### FINDINGS OF FACT Graham Family Short Plat (SP-08-02)

### RE: Graham Family Short Plat (SP-08-02)

The Kittitas County Community Development Services Department has determined that the Graham Family Short Plat is a complete application and hereby grants **conditional preliminary approval** subject to the following conditions:

GRAHAM FAMILY SHORT PLAT SP-08-02
PORTION OF SW 1/4 OF SECTION 4,
TOWNSHIP 19 NORTH, RANGE 16 EAST, W.M.

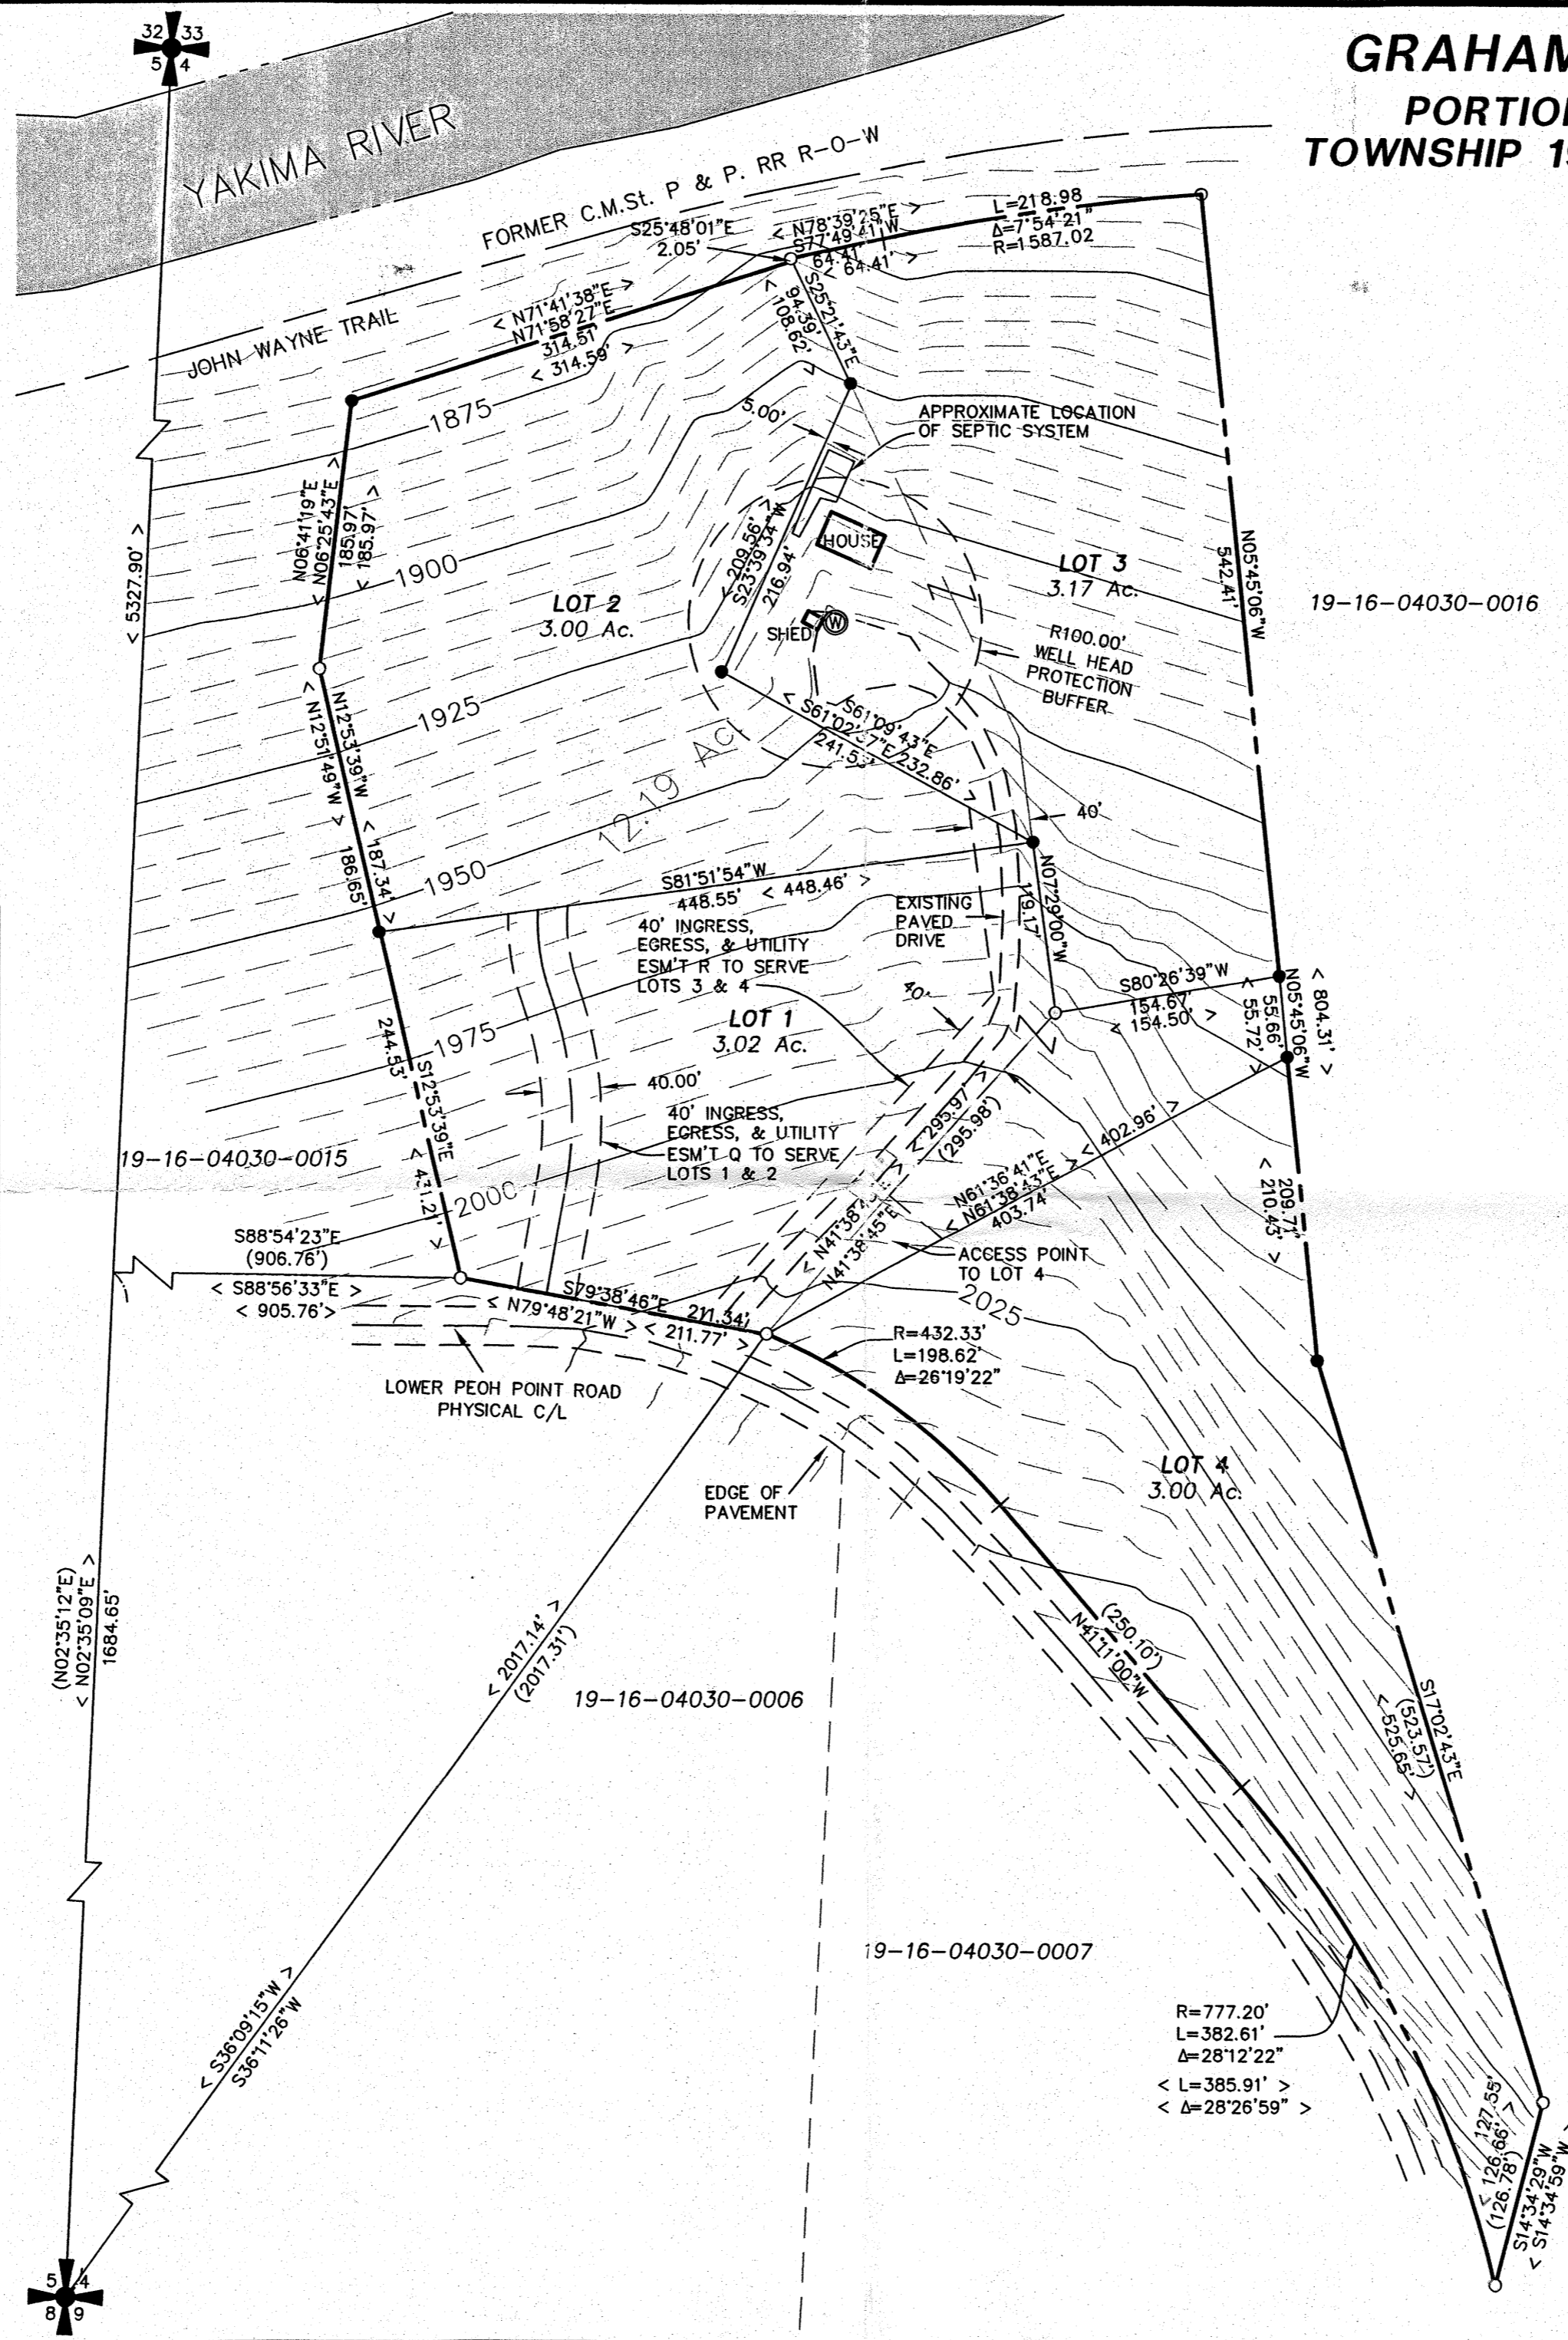
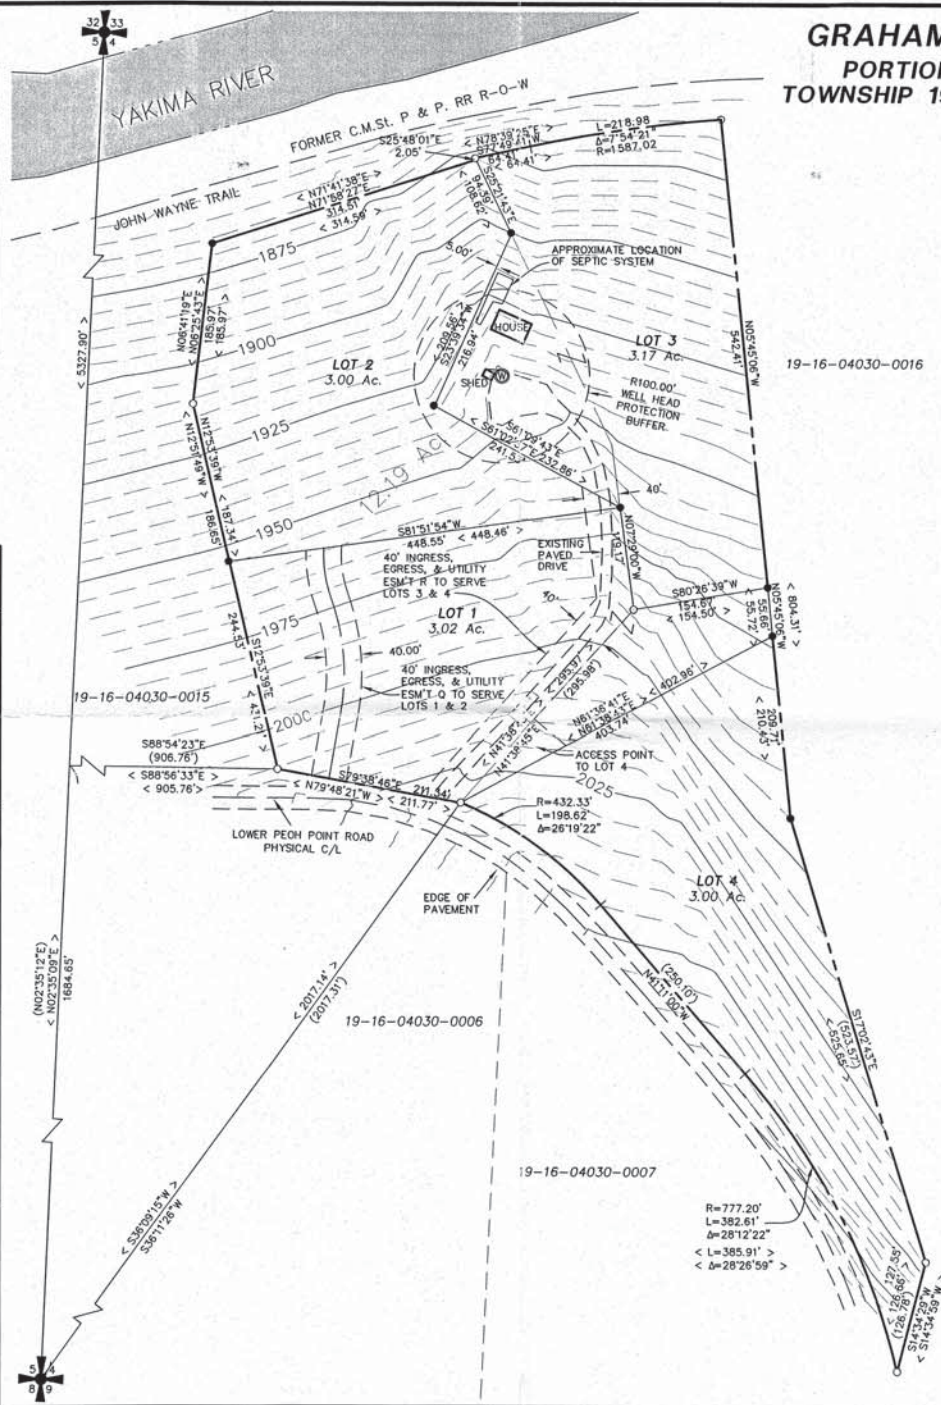
1. Both sheets shall reflect the short plat number SP-08-02.
2. All mitigations as set forth in the SEPA MDNS issued on April 25, 2008 shall be conditions of approval and of the project. Please see attached MDNS.
3. The applicant shall be responsible for meeting or exceeding all conditions and requirements set forth by the Department of Public Works, as listed in the attached memorandum.
4. A plat note shall be added as follows:

*The Graham Family Short Plat (SP-08-02) shall be considered as one project and therefore shall be limited to one groundwater withdrawal exemption for all four (4) proposed lots. All wells serving the Graham Family Short Plat (SP-08-02) shall be metered and records documenting water usage shall be kept and made available for public inspection. The cumulative daily withdrawal limit of all wells combined shall not exceed the 5,000 gallon per day exemption set forth by the Department of Ecology.*

5. A plat note shall be added as follows:

*Withdrawals of groundwater on the subject property are subject to the rules and regulations adopted and administrated by the Washington State Department of Ecology; this includes the use of water for irrigation. Legally obtained water must be used on-site.*

6. A plat note shall be added as follows:

*Kittitas County relies on its record that a supply of potable water exists. The approval of this division of land includes no guarantee or assurance that there is a*

*legal right to withdraw groundwater within the land division.*

7. A plat note shall be added as follows:

*All future development shall comply with the 2006 International Fire Code and its appendices.*
